## Uxbridge Town Centre West

1163-SK-0042 Location and Design of Oriel Windows DATE: 08.09.2022 REV: B

St. Modwen Homes | FBM Architects

Block 2A - South

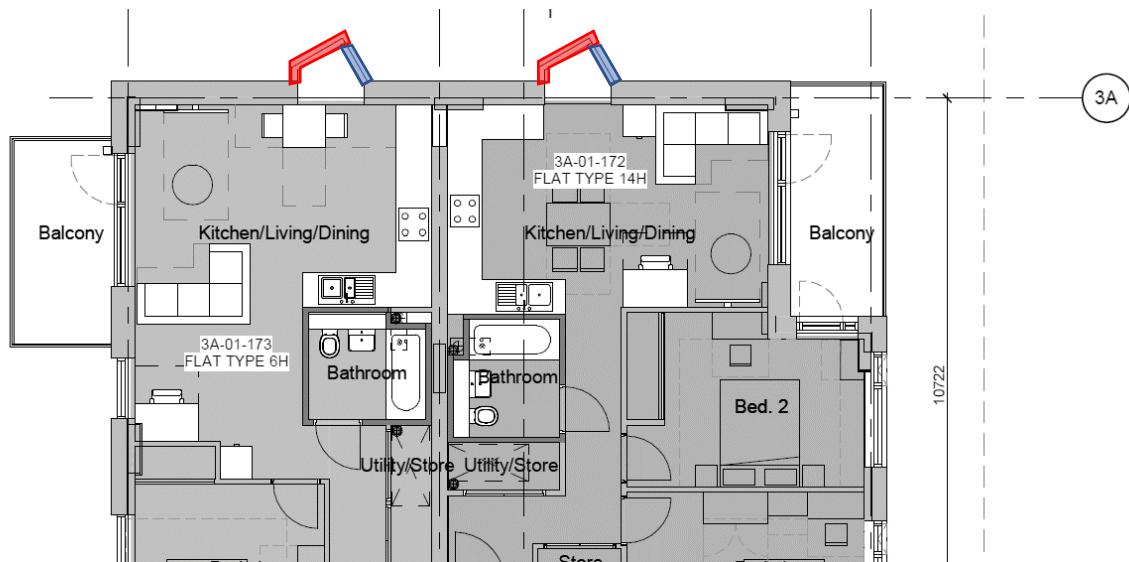
*I've reviewed the details submitted to discharge this condition and have some concerns with the proposed solution, in particular for the room below (Bed 2). This room is long and thin and unlike other rooms has no other windows to provide natural light or outlook. Please can you ask your architects to consider the solution for this room again, ideally enabling more outlook and natural light to the enter the room. For example, the 'red' section could include some obscure glazing up to 1.7m with clear glazing above. This would work for all examples, but my main concern is this particular room and the lack of amenity as proposed.*

To address these concerns, we propose to add a glazed panel to the portion highlighted in red in the diagram below to the oriel windows to Bed. 2 in Block 2A. The width of the glazing is sized to align with the module size of the zinc cladding alongside. Privacy manifestation to obscure visibility is proposed up to a height of 1.7m above FFL with clear glazing above. An elevation is included below the plan diagram of Block 2A and a typical detail is included at the end of this document.
